Contact Julia Puton
Tel 01992 556441
Email FRMConsultations@hertfordshire.gov.uk

Date 26 June 2019

RE: 6/2019/0857/MAJ – Stanborough Park, North Stanborough Park, Stanborough Road, AL8 6DF

Drawing Status
PRELIMINARY
Project
**STANBOROUGH PARK
SPLASHLANDS**
Title
CATCHMENT PLAN
Drawing No
171116-CON-X-00-DR-C-1010

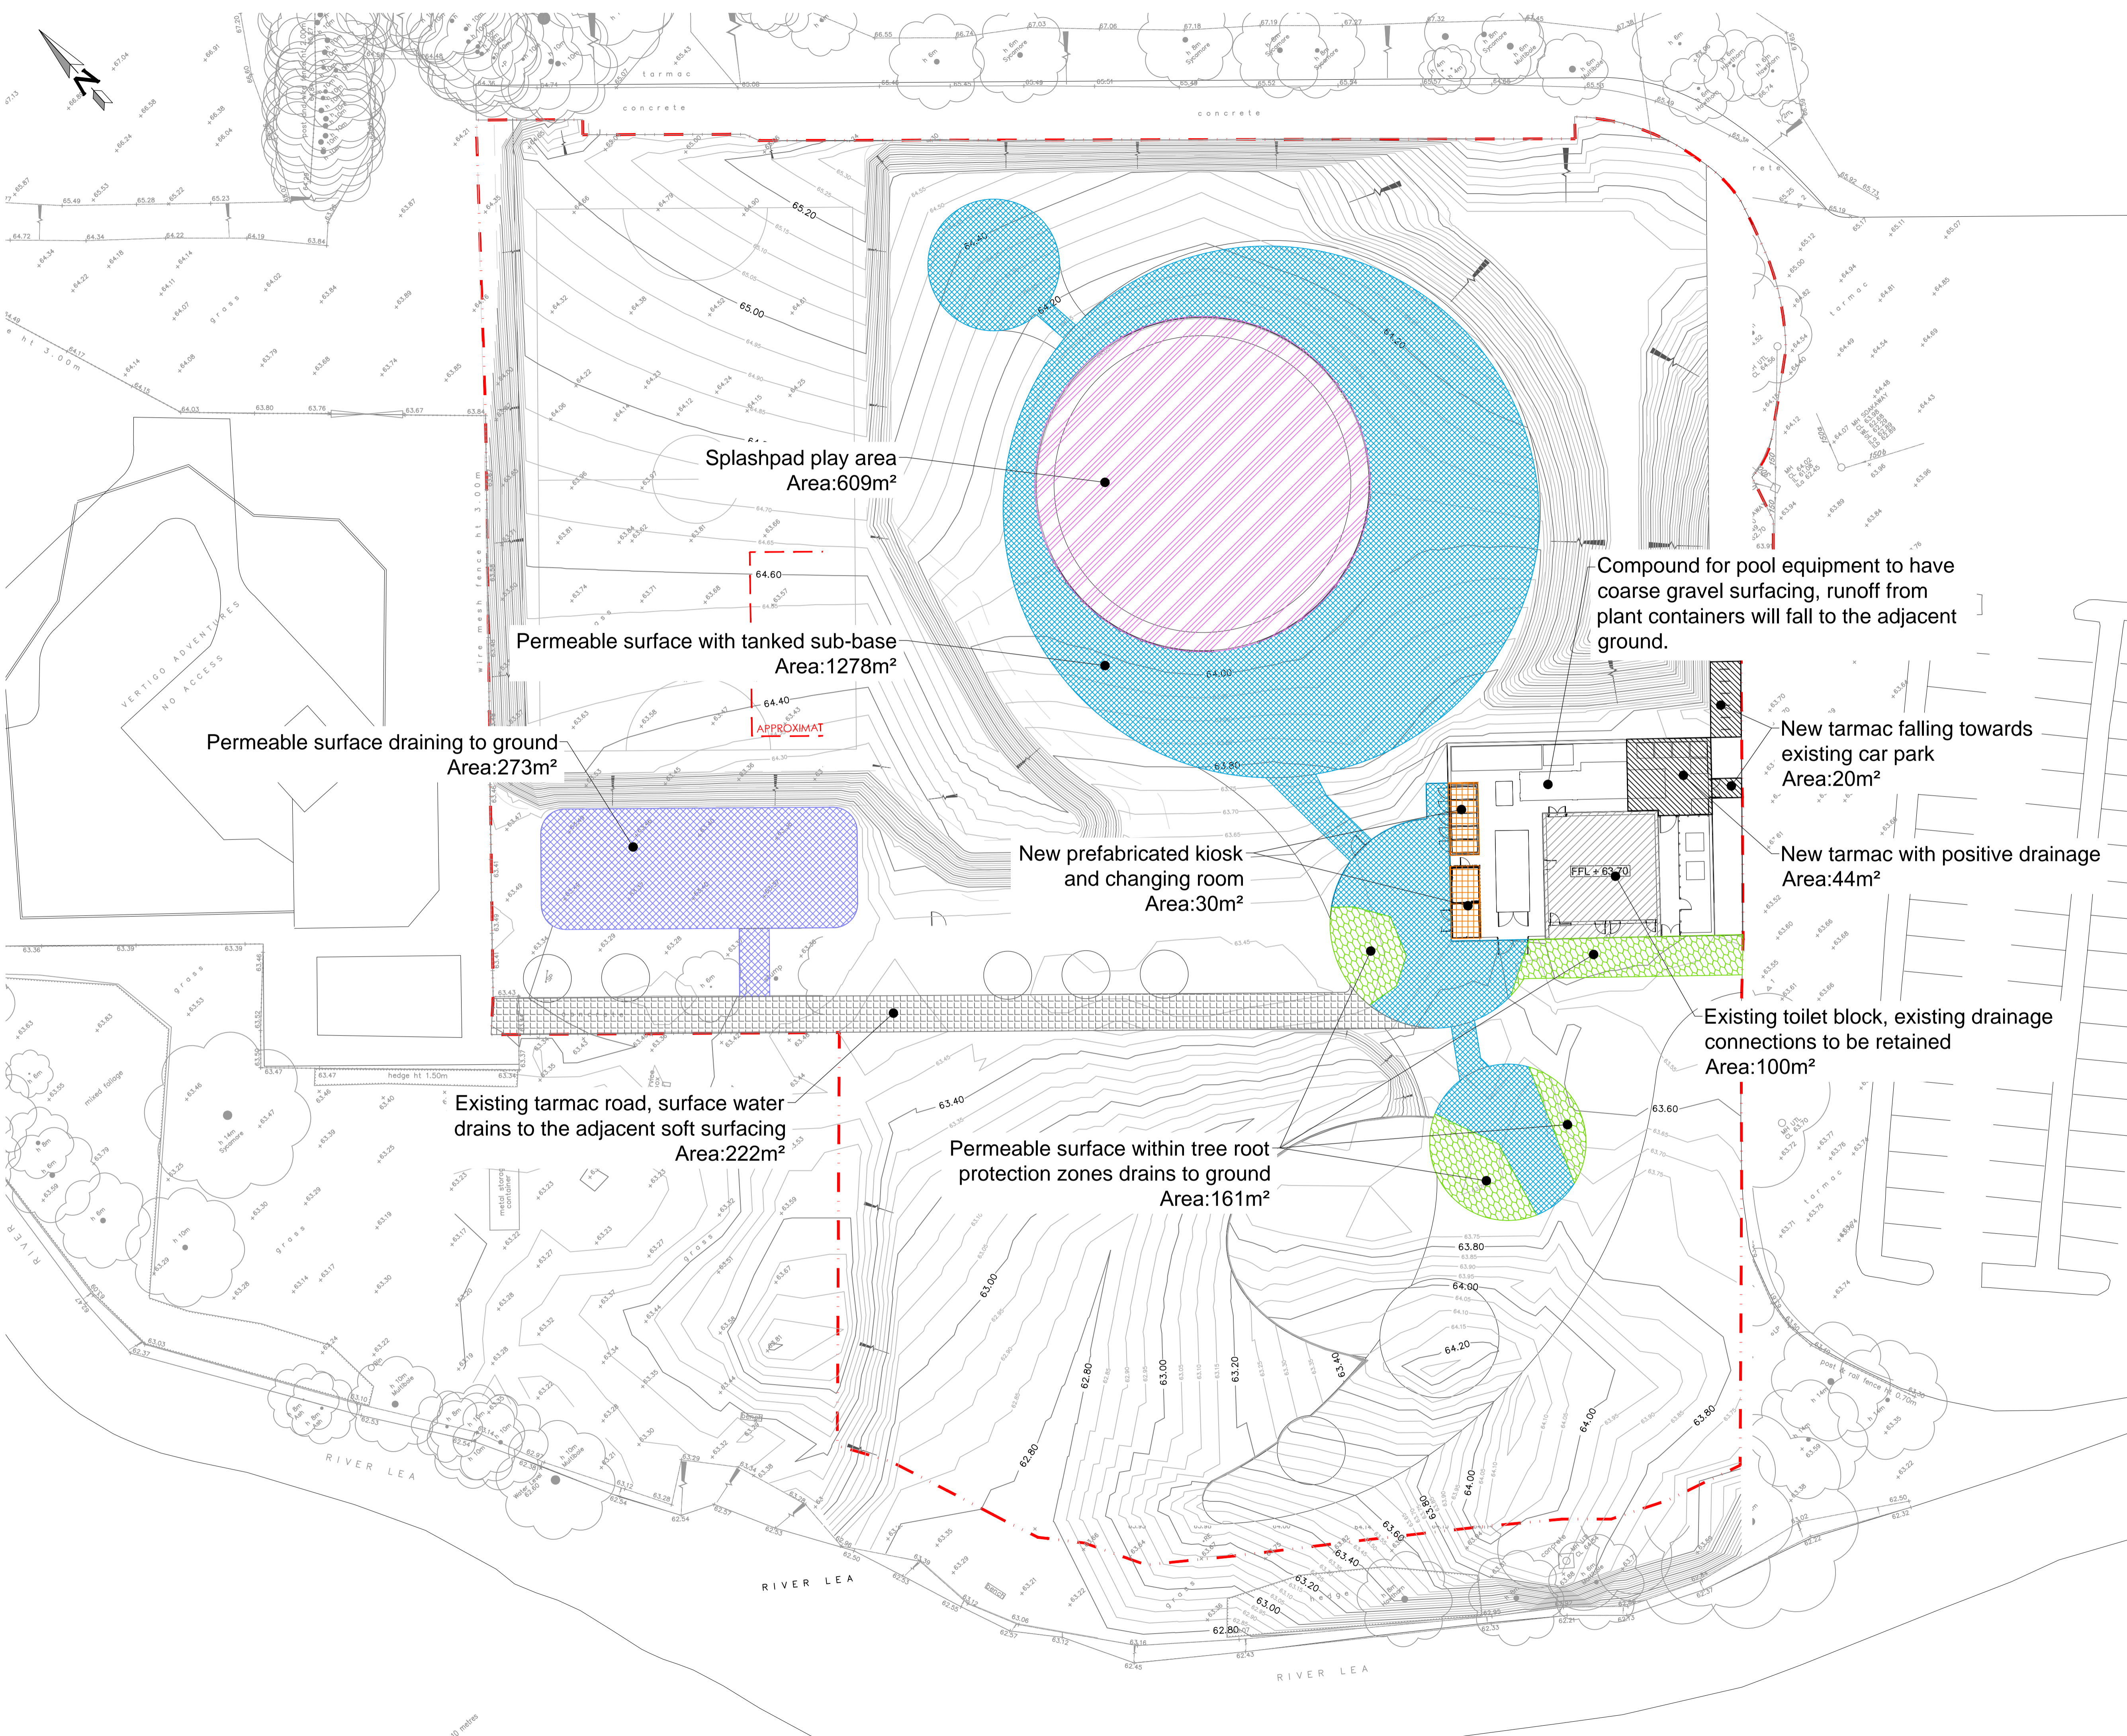
1. We note that the applicant has submitted an updated drainage strategy that now includes two underground permavoid tanks.

We would advise that the applicant should provide an updated modelling to support the updated drainage strategy.

2. We note that the applicant has updated the site location drawing. We understand that now the existing access road is included within the application site boundary.

The applicant has not included any information on how the surface water run-off from the access road will be managed. Therefore, the applicant should clarify how they intend to drain the access road.

The applicant should explain if there is an existing system, how it works and if it is intended to be used. The applicant must demonstrate if they intend to connect to the local surface water sewer that the relevant water company accepts the proposed discharge rate. As the LLFA, we need to ensure that all the opportunities to improve the situation on site and in the surroundings of the development have been considered.
